From: sara@krdistrict.org
To: [Jeremiah Cromie](#); [Pat Nicholson](#); [Candie Leader](#); [Holly Erdman](#); [Jesse Cox](#)
Cc: [Jeremy Johnston](#)
Subject: RE: BL-21-00012 Niehoff - Notice of Application
Date: Thursday, June 3, 2021 2:09:35 PM

Portions of the Niehoff BLA lie within the Kittitas Reclamation District (KRD) however it does not contain irrigable ground. KRD requests the following plat notes:

Subject: BL-21-00012 Niehoff - Notice of Application

NIEHOFF/RICARD PROPERTY

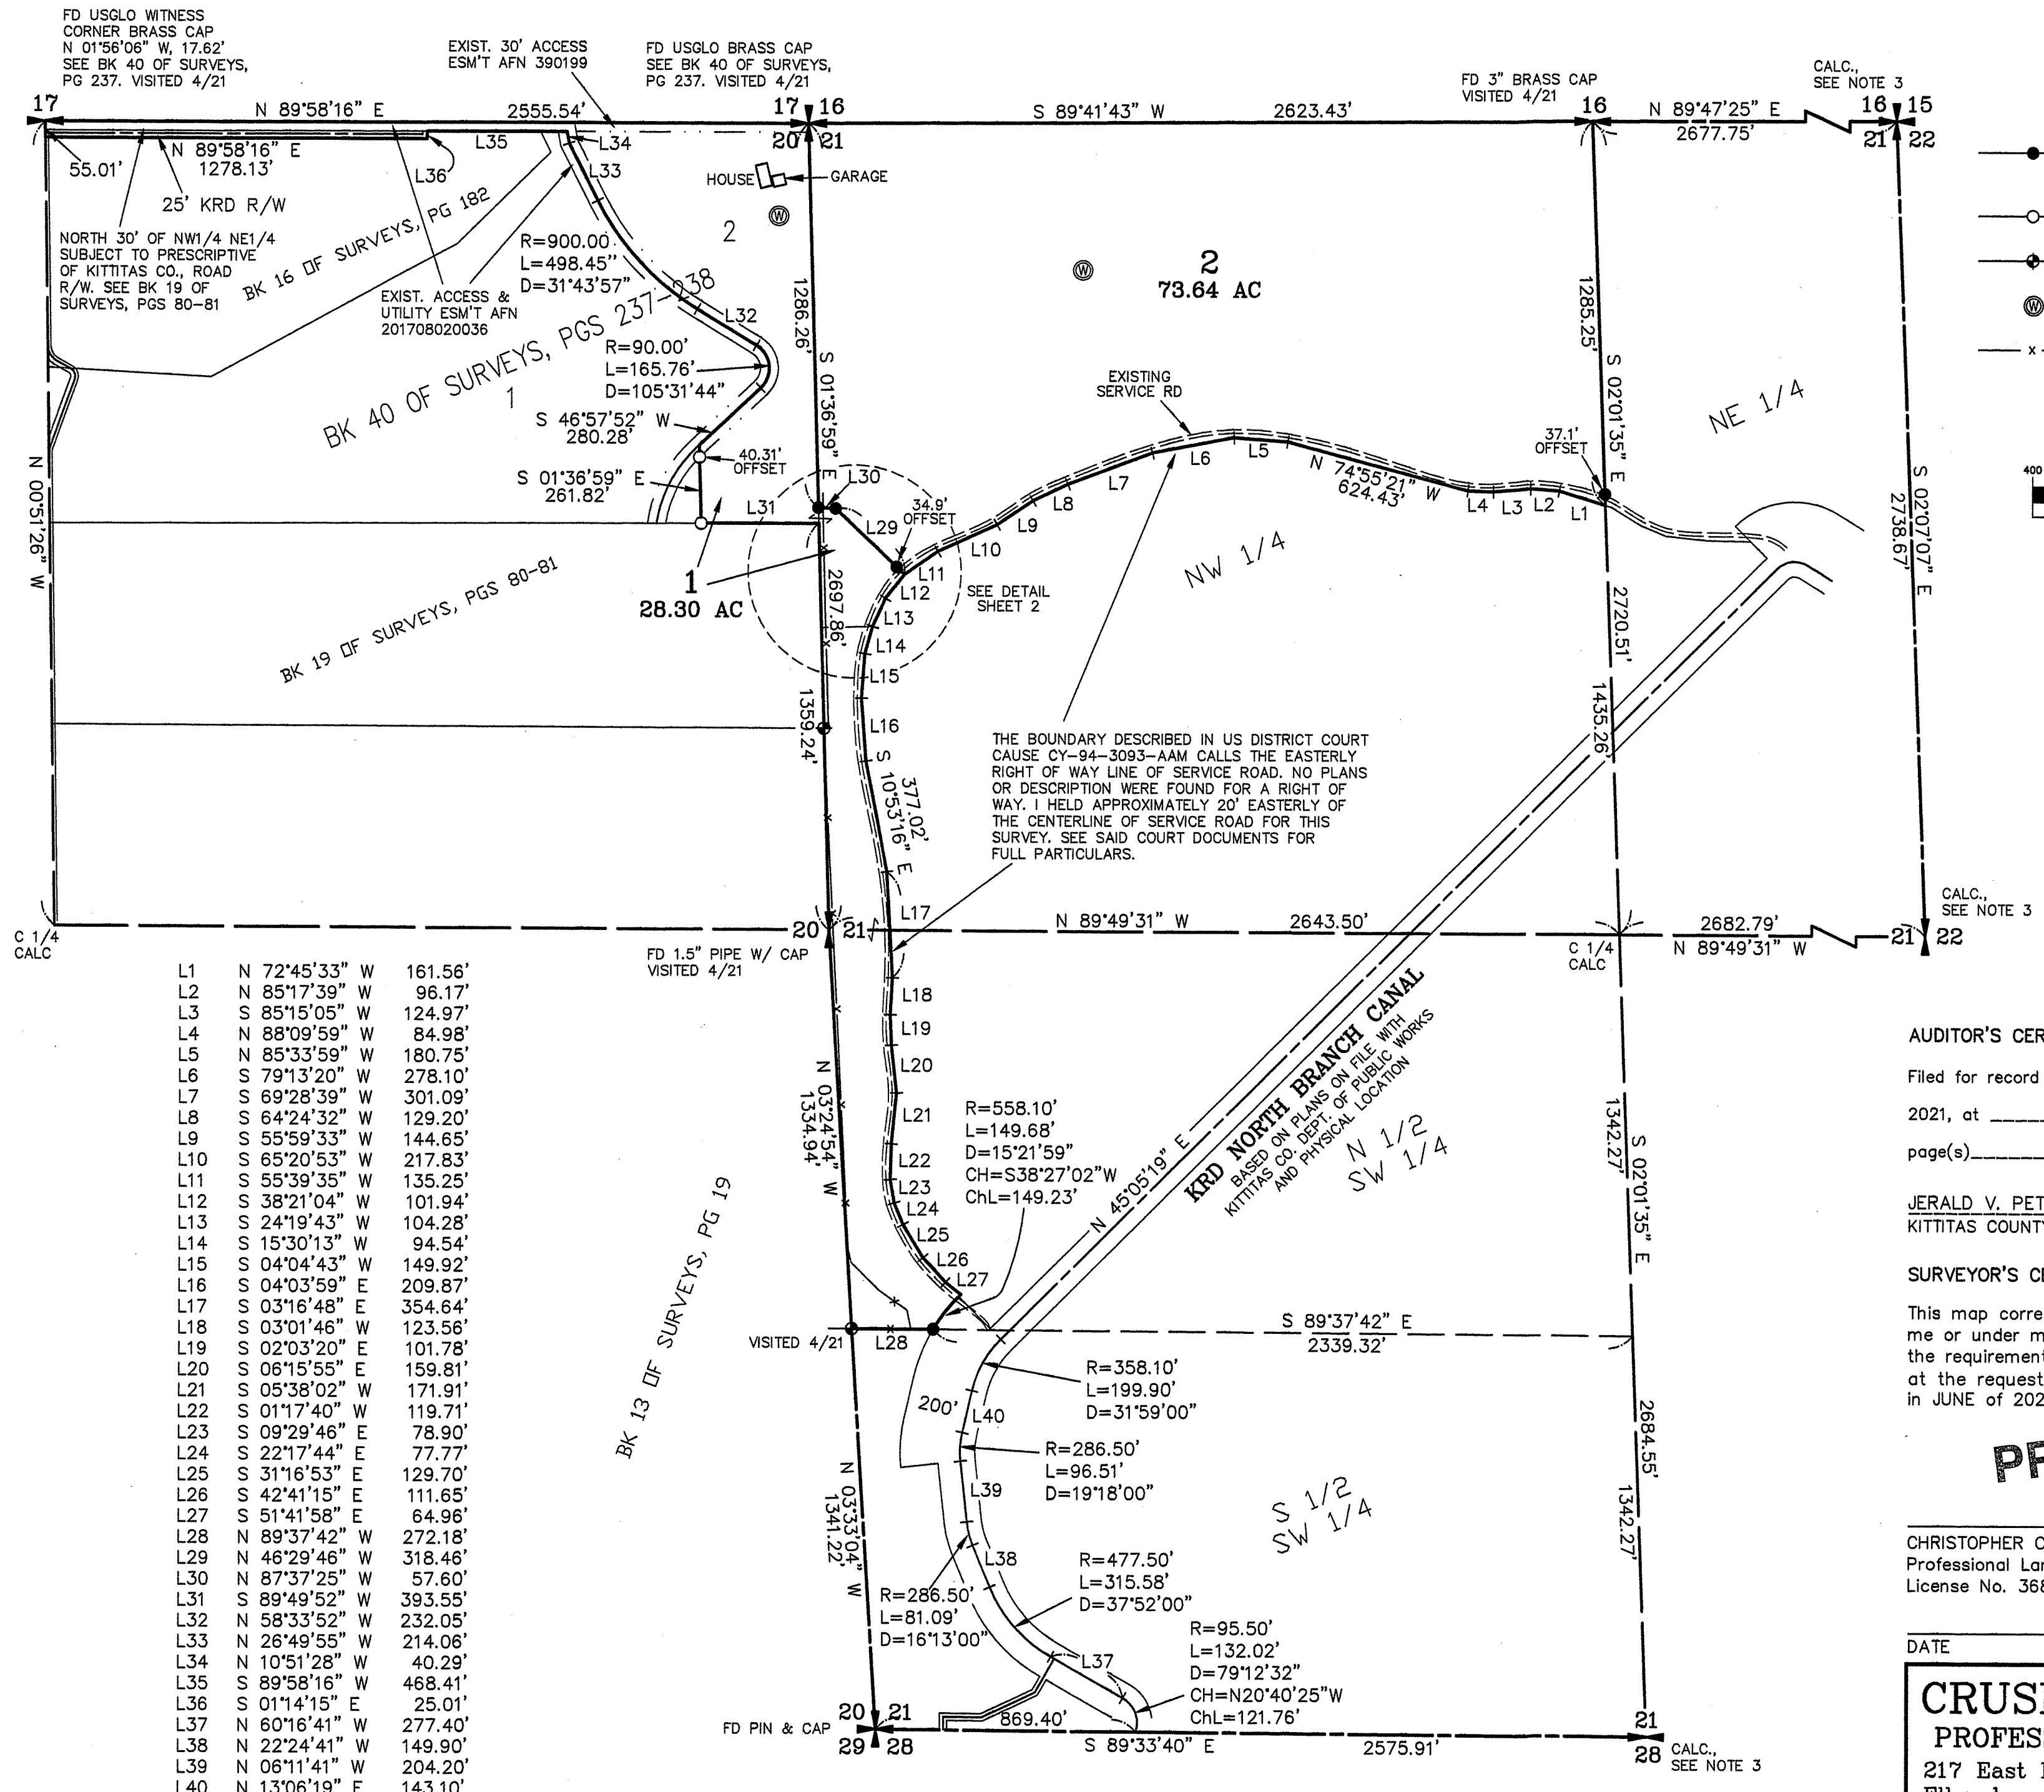
1. "KRD Operations and Maintenance roads are for District use only. Residential and recreational use is prohibited."
2. "KRD is only responsible for delivery of water to the highest feasible point in each 160-acre unit or designated turnout. The KRD is not responsible for water delivery loss (seepage, evaporation, etc) below the designated turnout."
